Recommendation Report for Planning Permission

REF NO: CM/4/25/PL

LOCATION: Land to the West of
Crookthorn Bryre
Climping
BN17 5QU

PROPOSAL: Erection of 1 No. two storey dwelling (self build) (resubmission following CM/15/24/PL). This application affects the setting of listed buildings, is a Departure from the Development Plan and is in CIL Zone 5 and is CIL Liable as a new dwelling.

WEST ELEVATION

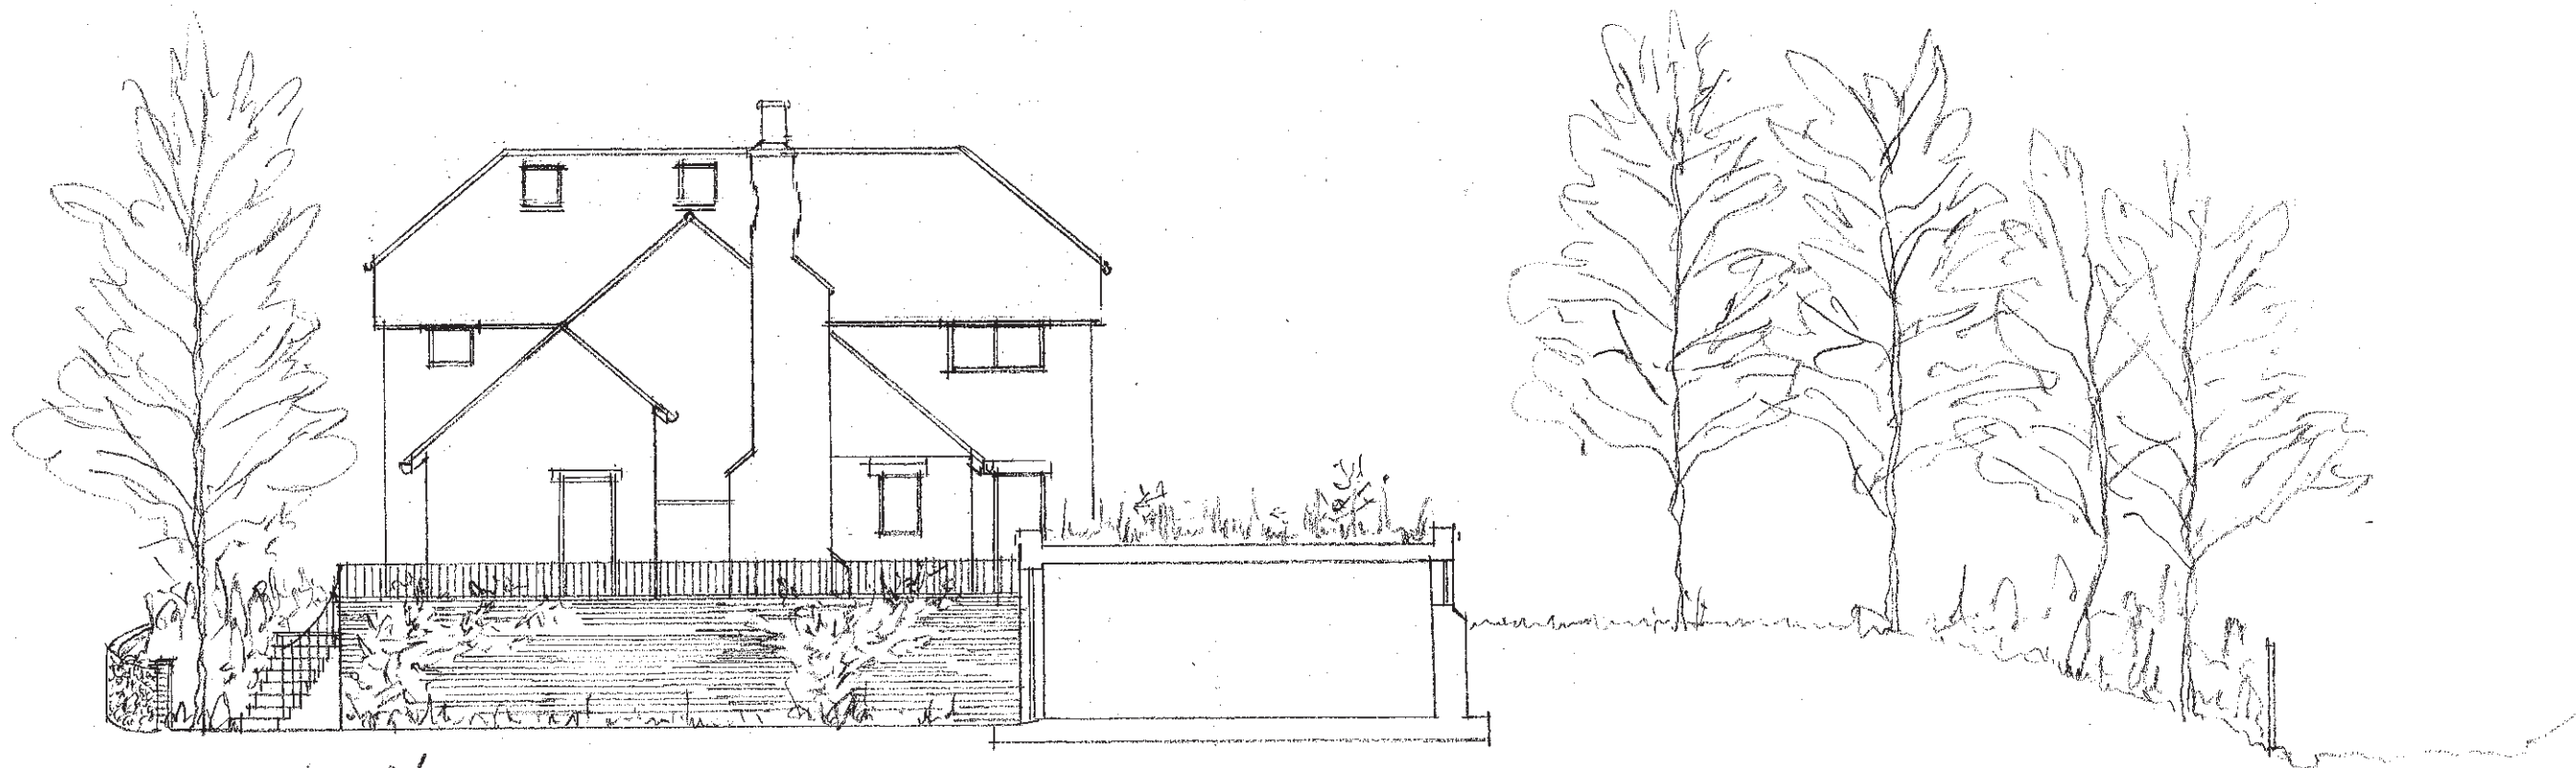
Most of the materials proposed are traditional and appropriate (subject to details), having been drawn from the local context, but the proposal features a substantial number of glazed openings that are of UPVC materials and do not appear to be laid out in such a way that would be expected for a former agricultural building. This contributes to what is a more visually domestic and modern building, rather

than one which is a convincing depiction of an agricultural building conversion. Other features such as the chimney, the quantity of rooflights and solar panels, the separation of ground and first floor within the central two-storey component that is prominent from the outside which would usually have been vaulted in an agricultural barn, and the flat roofed brick and timber garage, all further contribute to the domestic appearance of the building and site, diminishing the more traditional 'barn conversion' style that would be more appropriate.

The proposal features a substantial number of UPVC fenestrations with a layout more akin to a residential unit than one that might be derived from a former agricultural building. This contributes to what is a more notably domestic building, rather than one which accurately mimics the organic conversion of an agricultural building. Additionally, the chimney, the quantity of rooflights and solar panels, the separation of ground and first floor within the central two-storey component that is prominent from the outside and which would usually have been vaulted in an agricultural barn, and the flat roofed brick and timber garage, all further contribute to the more domestic appearance of the building and overall site, diminishing the apparent agricultural conversion design intention that would be appropriate for the locality.

ROOF PLAN

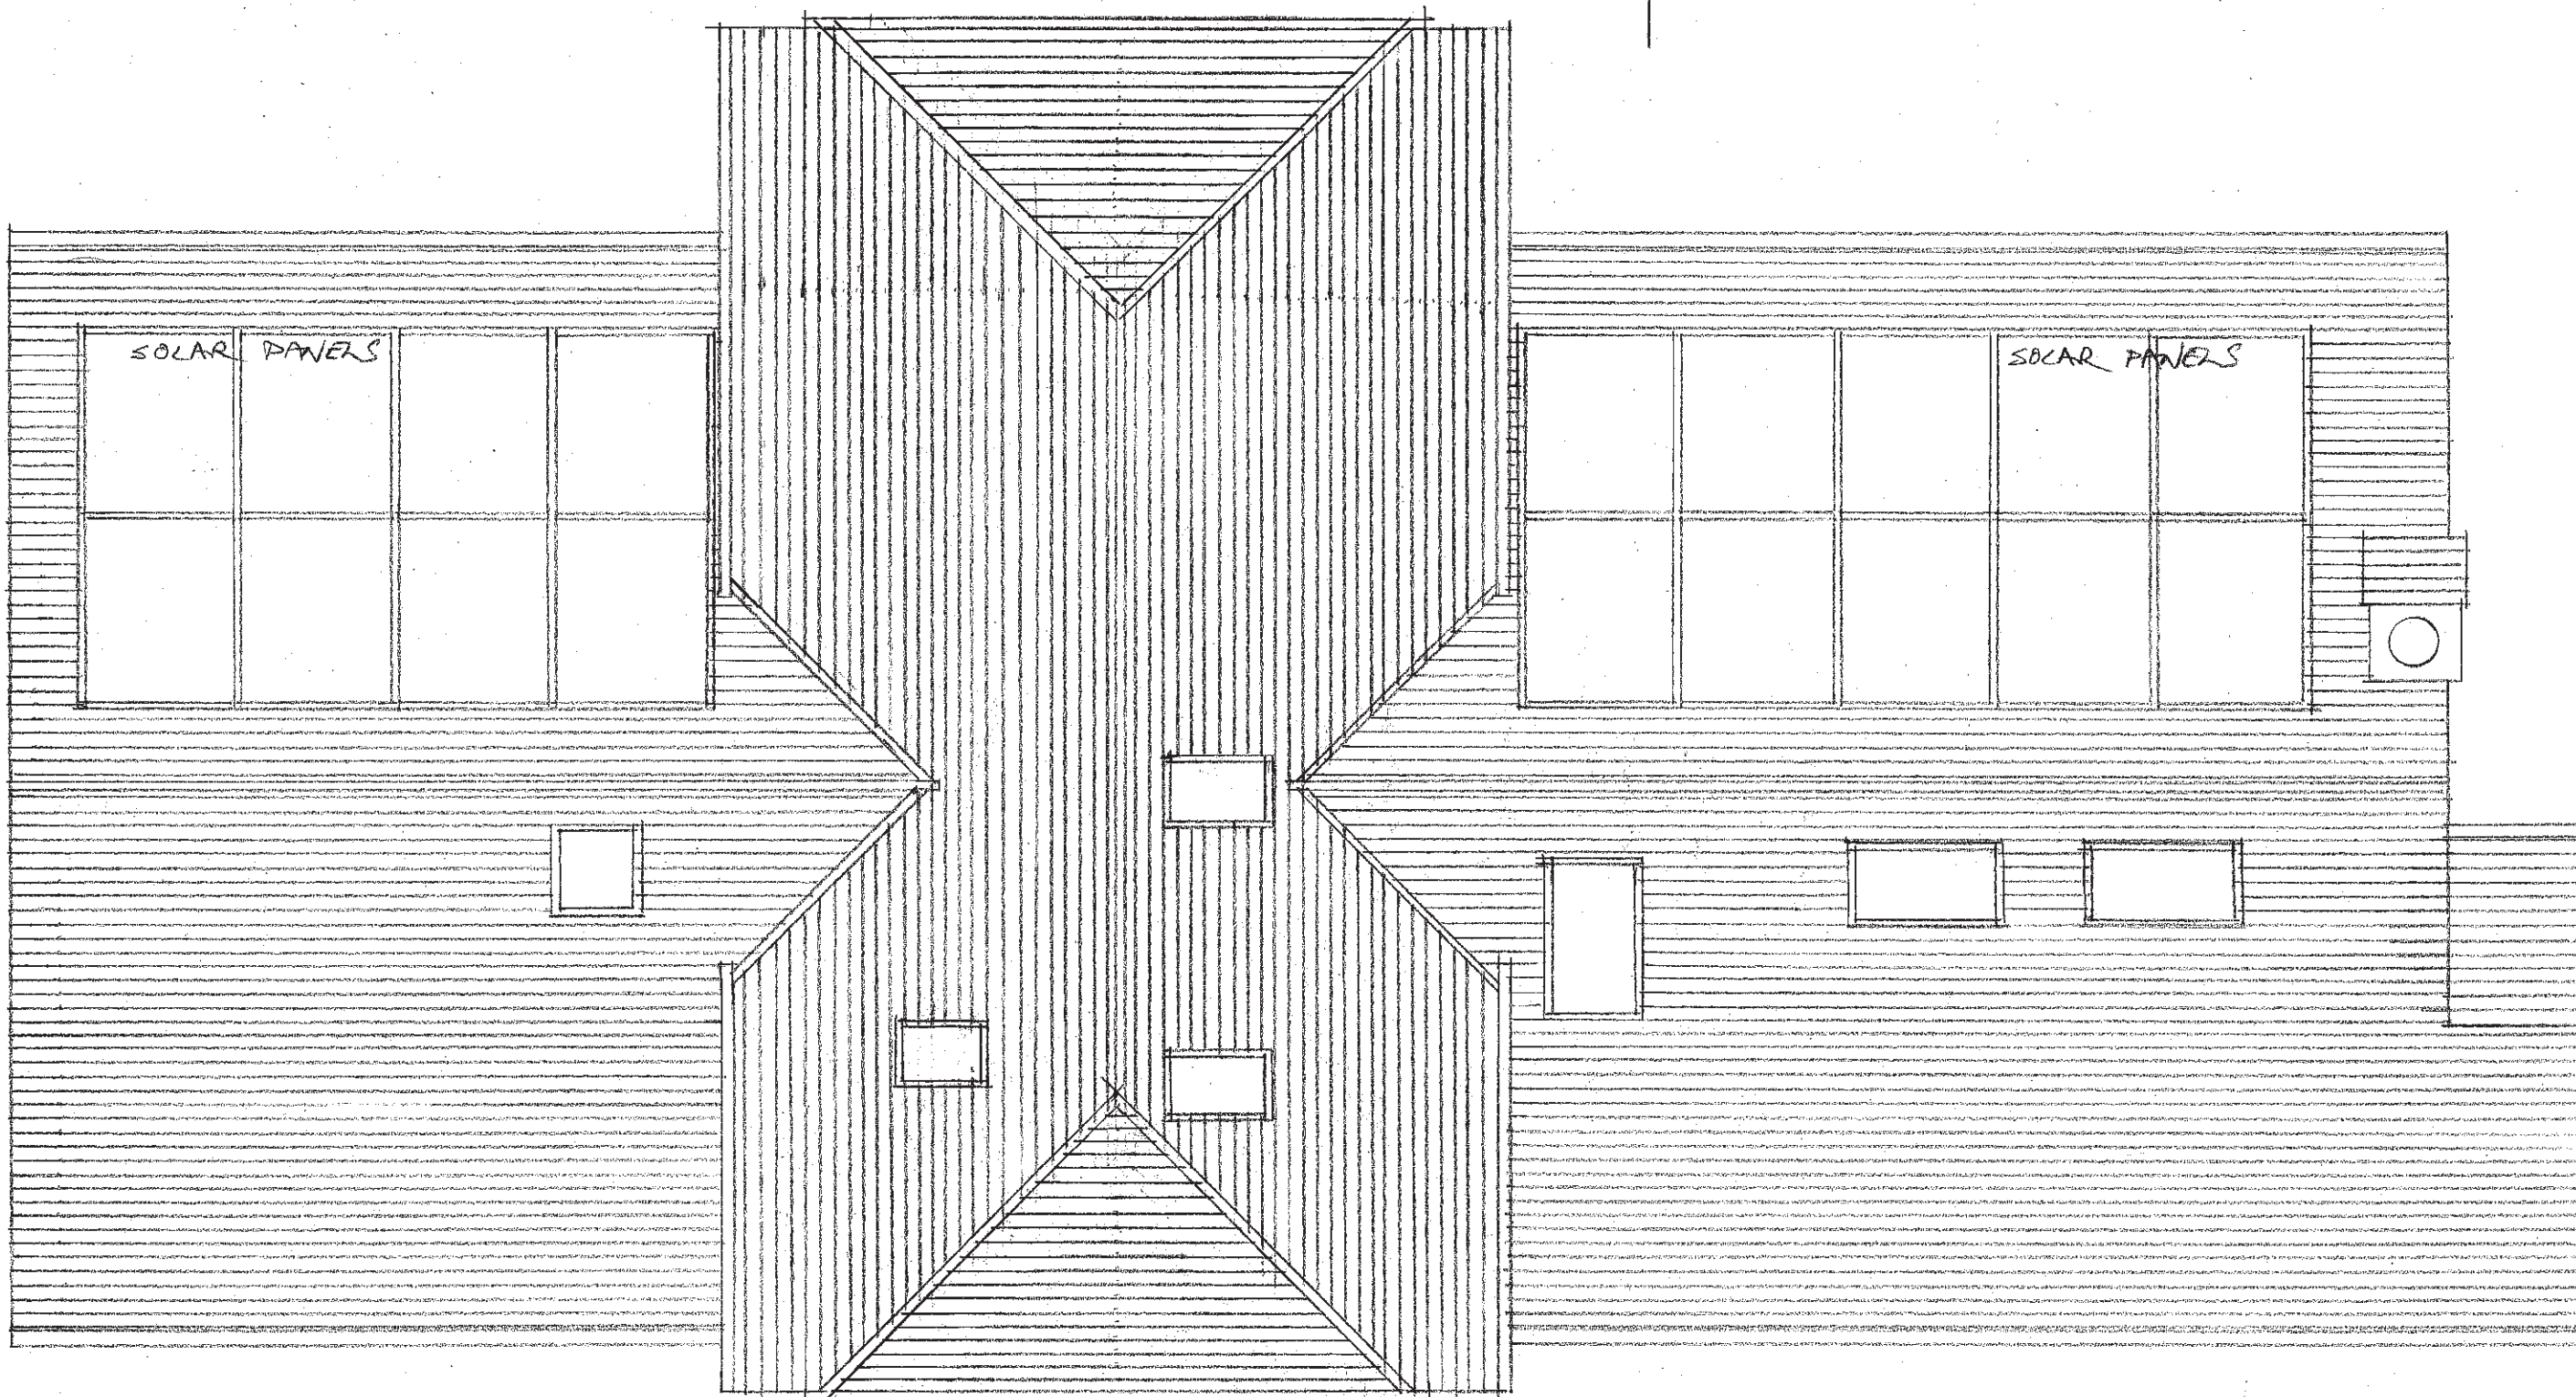
Inset solar panels are proposed to the rear roof slope, however, in the sensitive heritage context, the proposed quantity of solar panels would not be appropriate. It is noted that extensive solar panels are present on 'Lower Dairy Barn' to the east of the site, and at 'The Hayloft' to the north, however, these have not been reviewed under an application for planning permission, and it is clear from the comments of the Conservation Officer, that these are not appropriate in the context. Alternative energy efficiency measures such as Air Source Heat Pumps would be more appropriate in the context and would have been secured by a condition had this application been approved.
